**BOTLEY WEST SOLAR FARM
OXFORDSHIRE HOST AUTHORITIES
RESPONSE TO
4 SEPTEMBER 2026 CONSULTATION
DEADLINE: 4 OCTOBER 2026**

Botley West Solar Farm (EN01014)

OXFORDSHIRE HOST AUTHORITIES RESPONSES TO CONSULTATION 1 DOCUMENTS

Comments on applicant's documentation submitted in response to the information request of 14 April 2026 (re-issued 20 and 28 April 2026)

Drawing file: EN010147 / EN010147-000447-EN010147_APP_6.4 ES - Figures 2.1a - 2.4d - Illustrative Masterplan.pdf

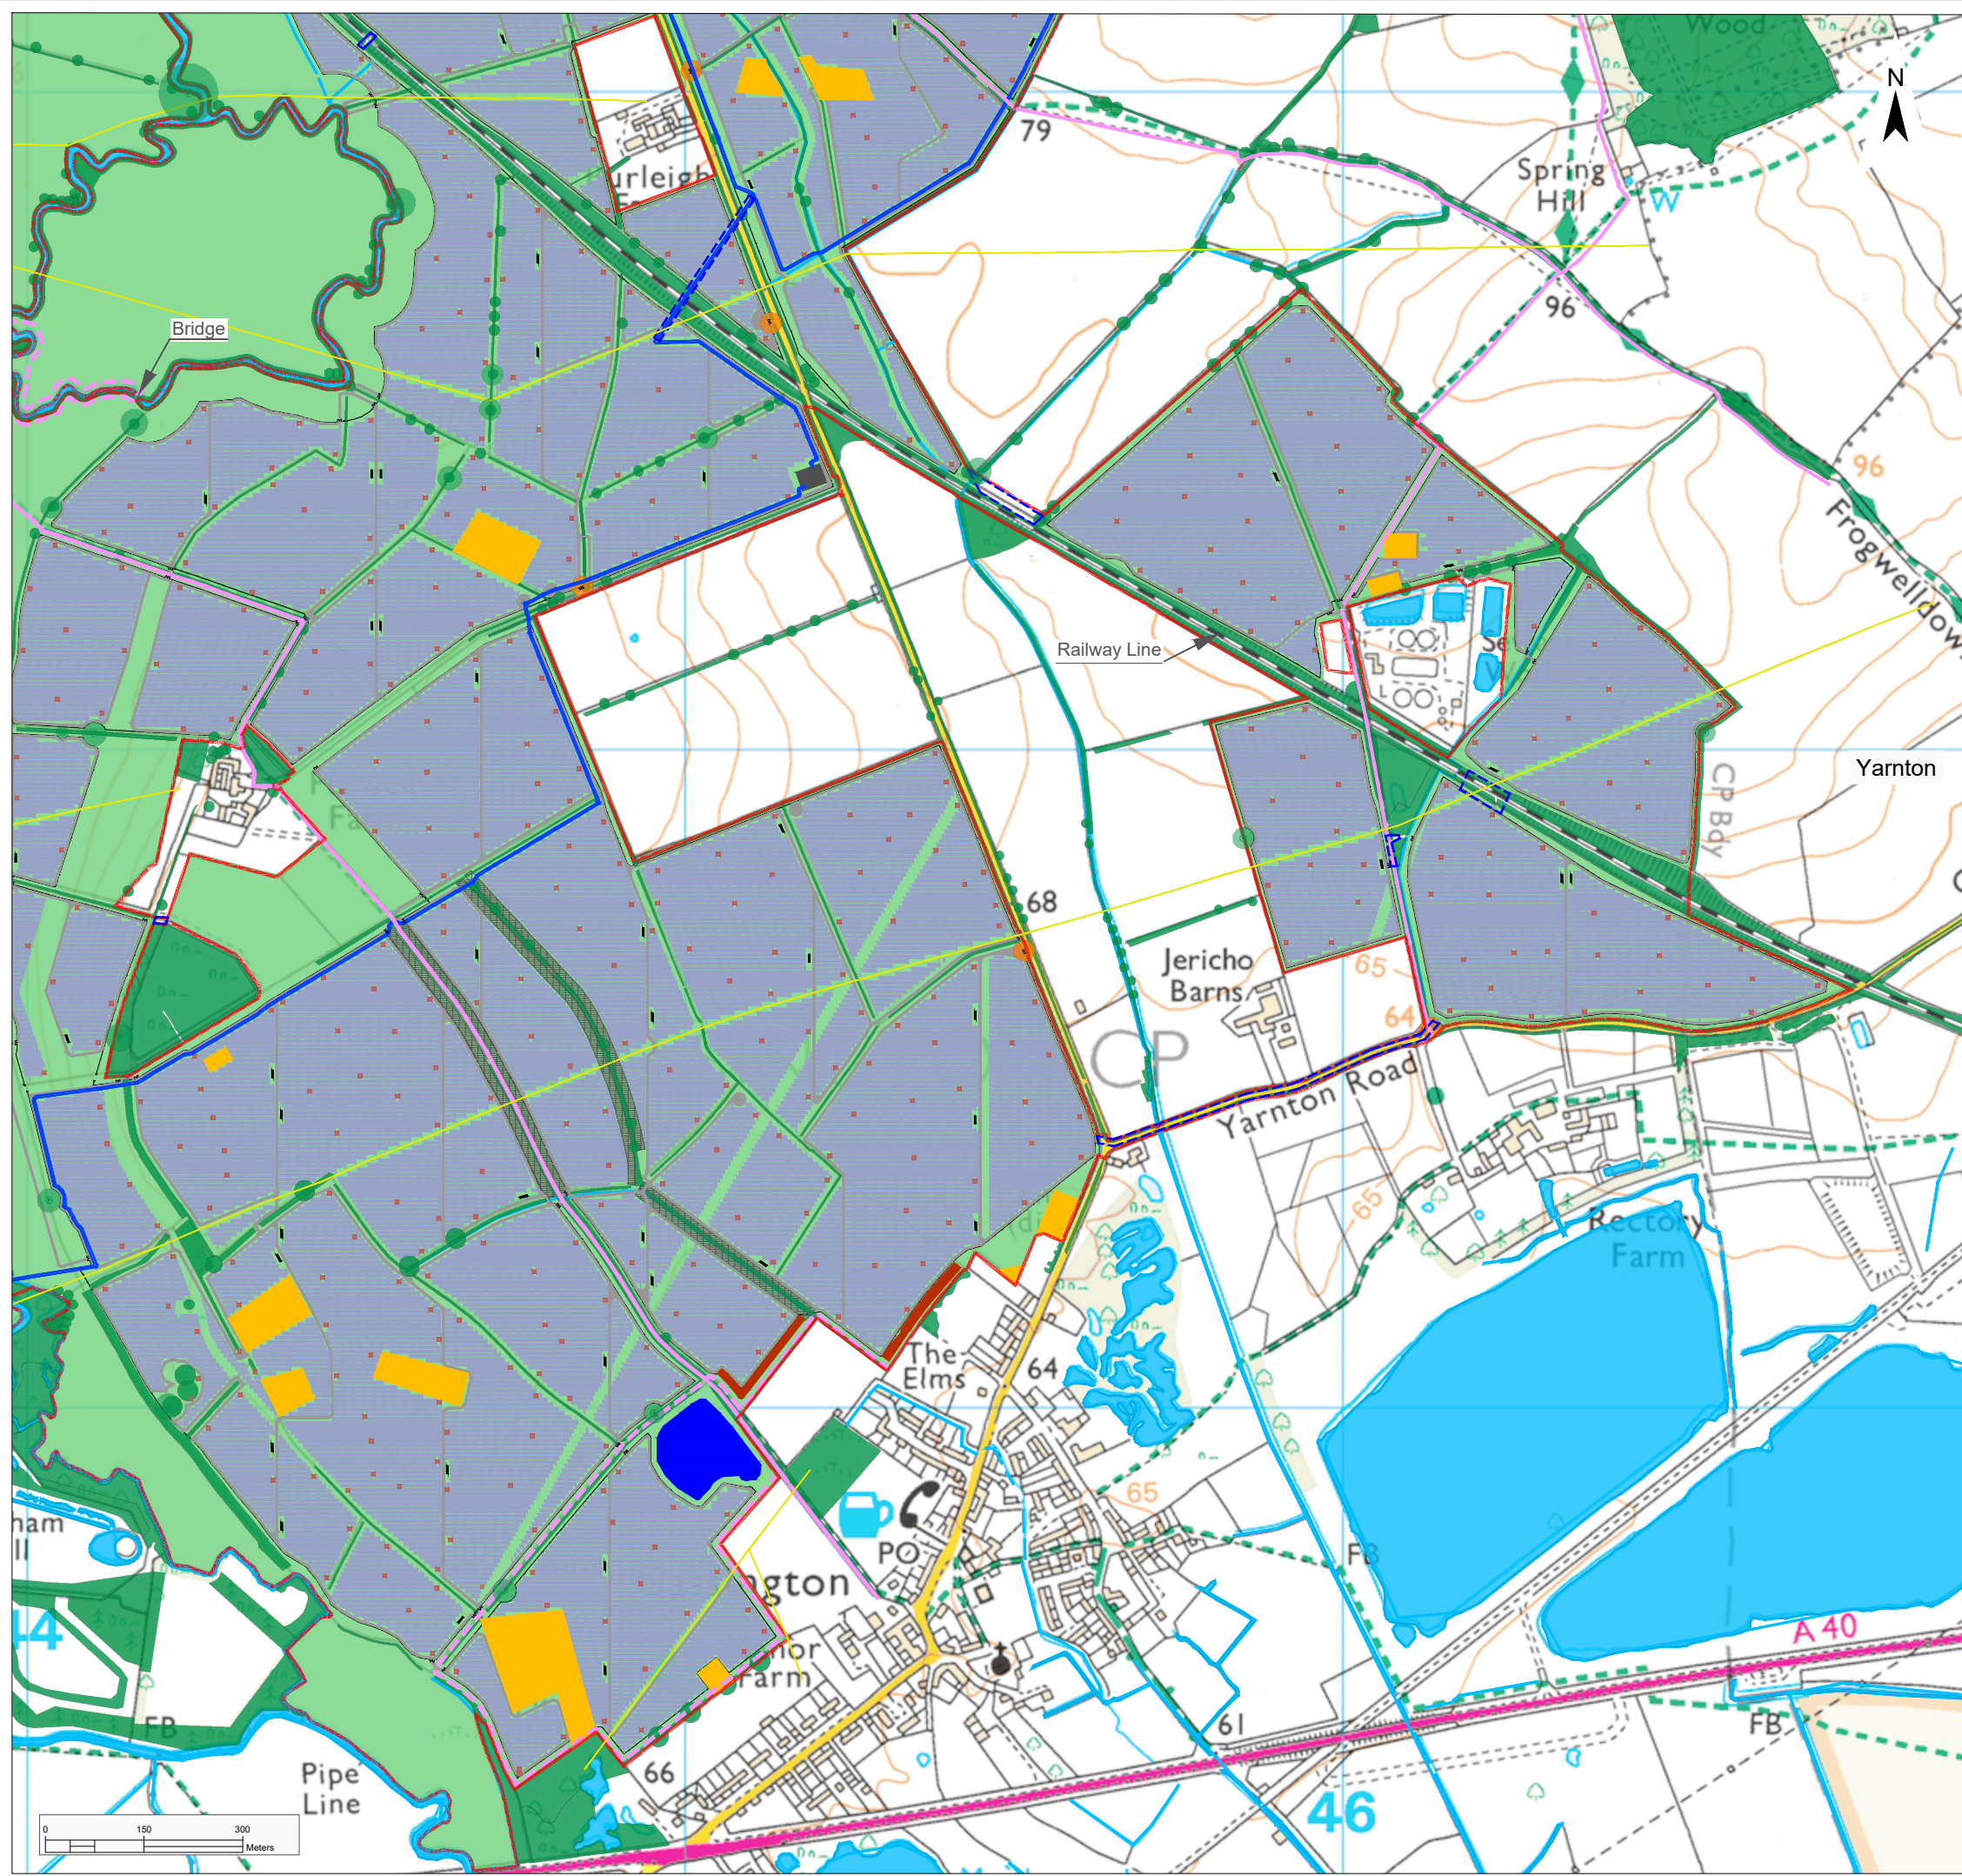
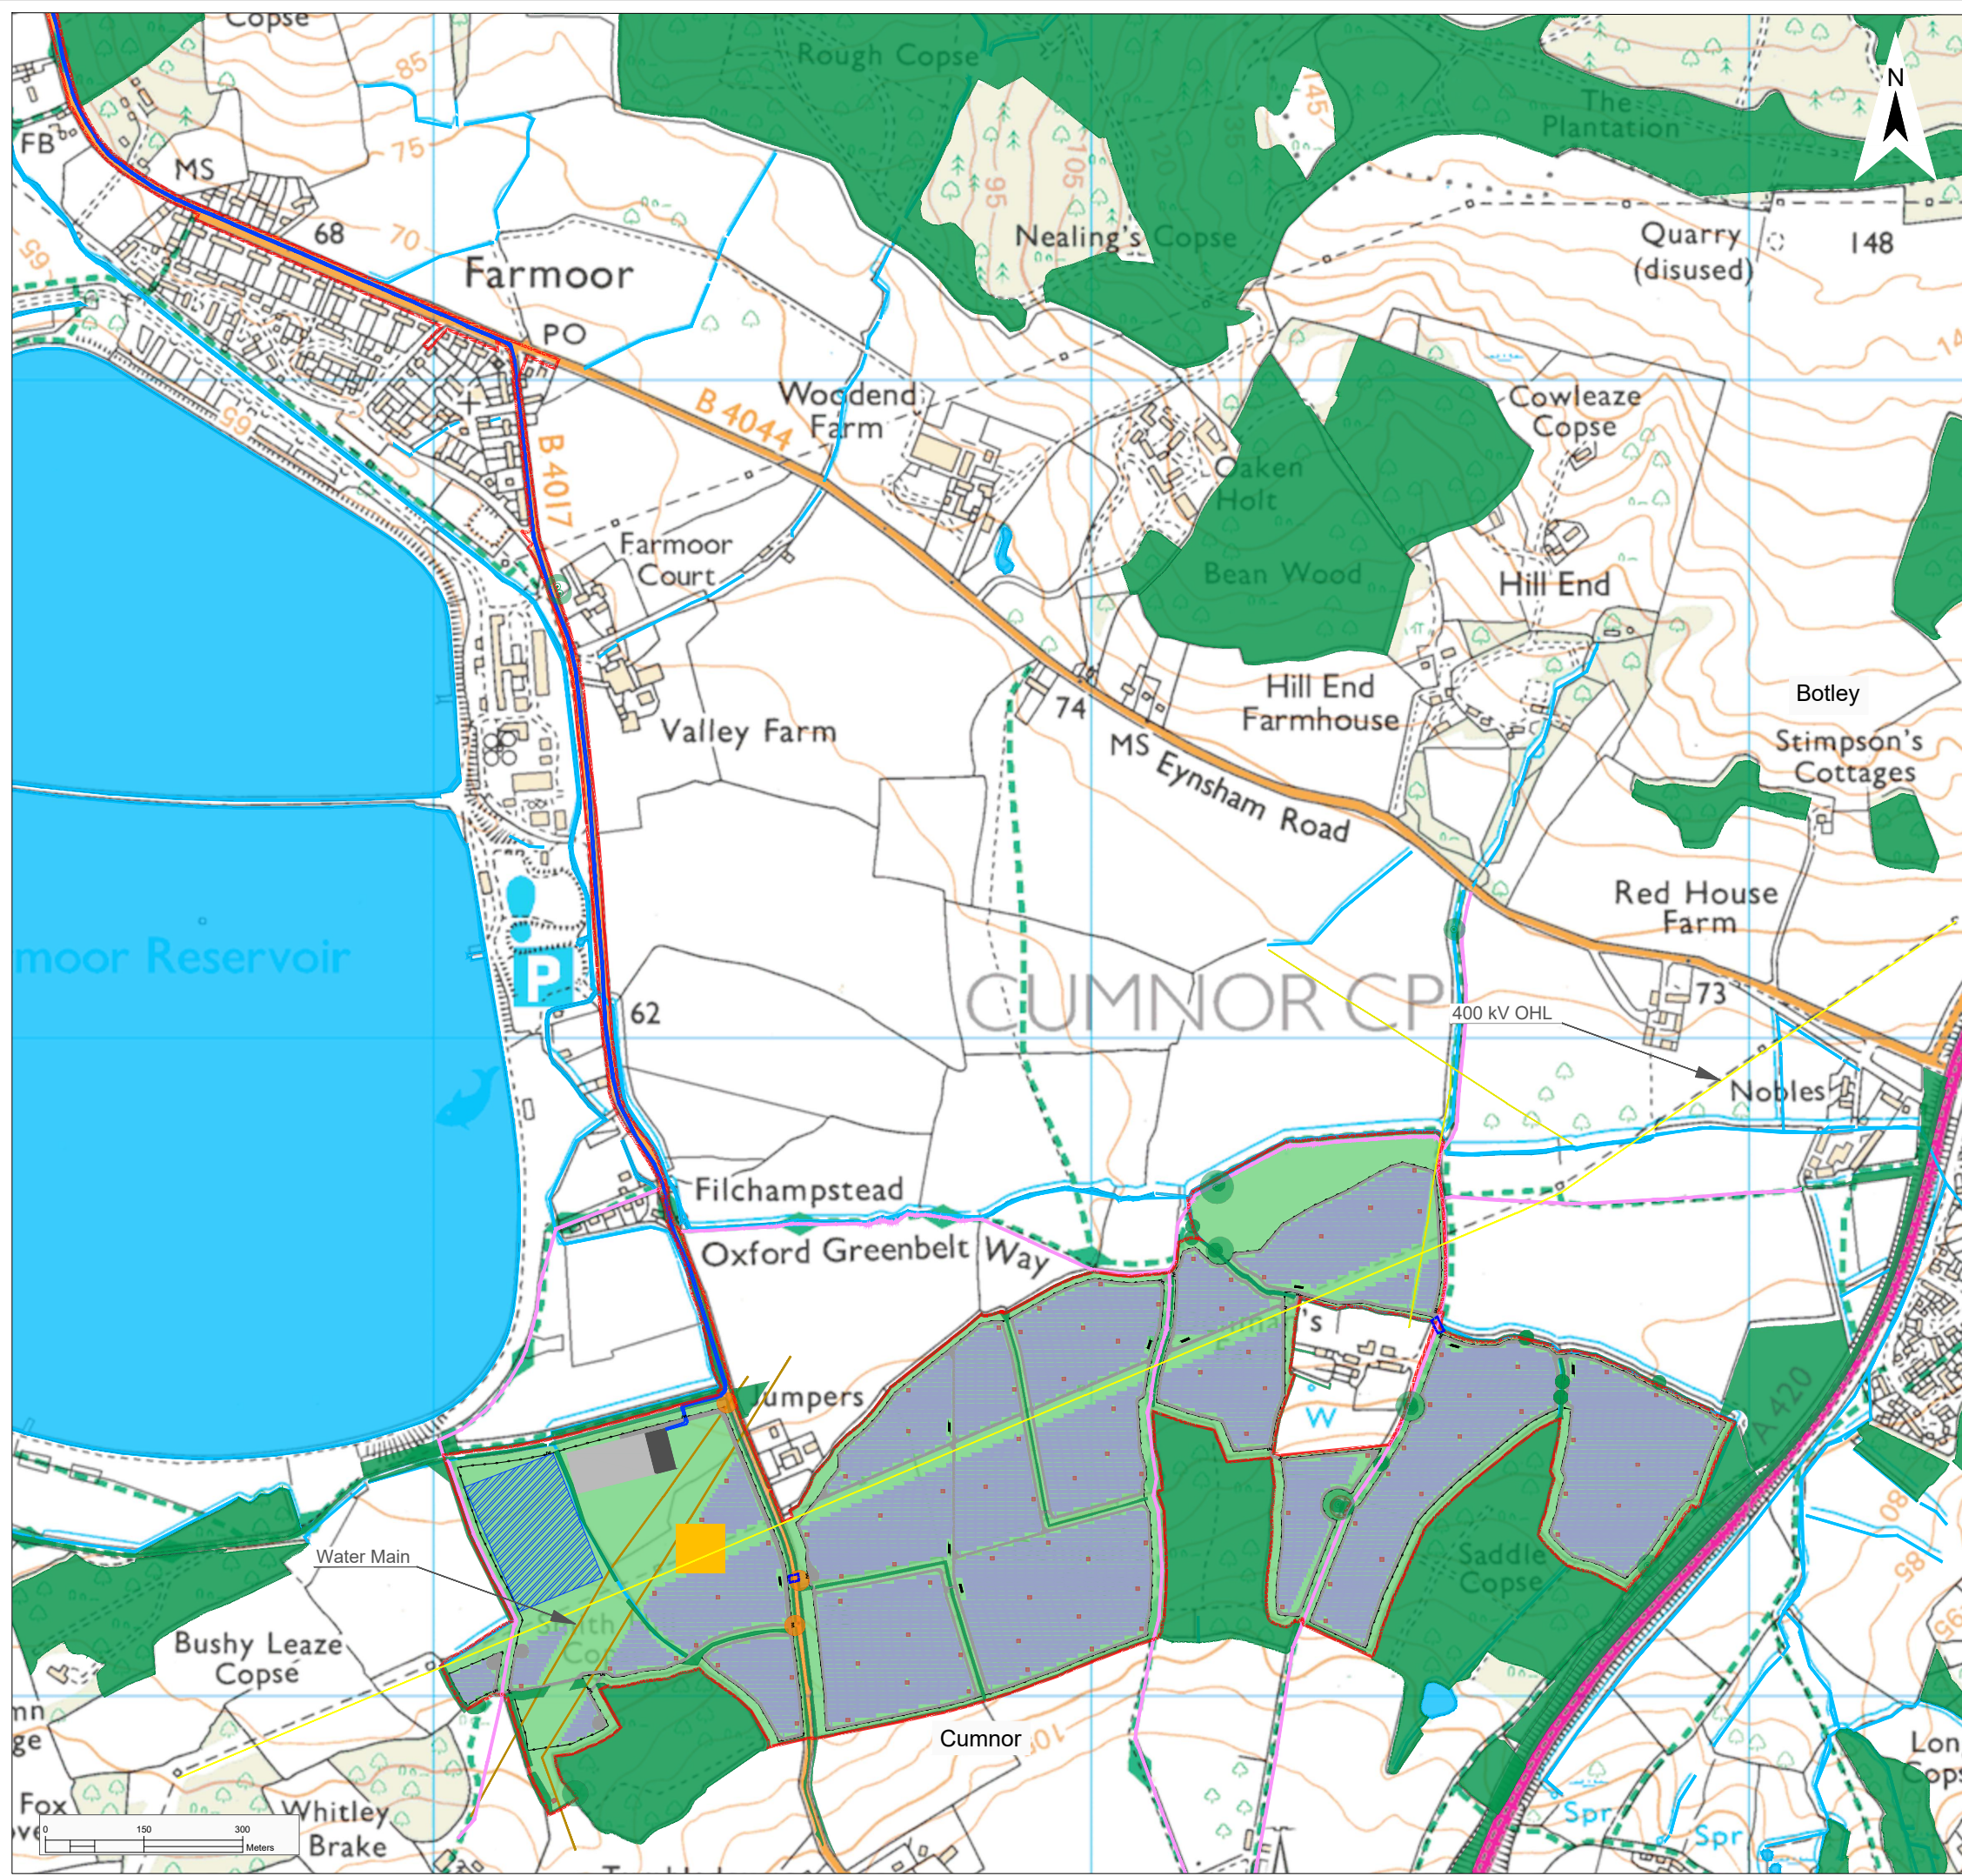
The OHA wishes to draw the Secretary of State's attention to previous comments OHA provide in their response [REP6-118] for panel removal on a field-by-field basis. Whilst Rev 5 is a betterment on the Rev 4 plan, the changes in the OHA's view do not go far enough in delivering a scheme that minimises landscape and visual impacts to a more acceptable level.
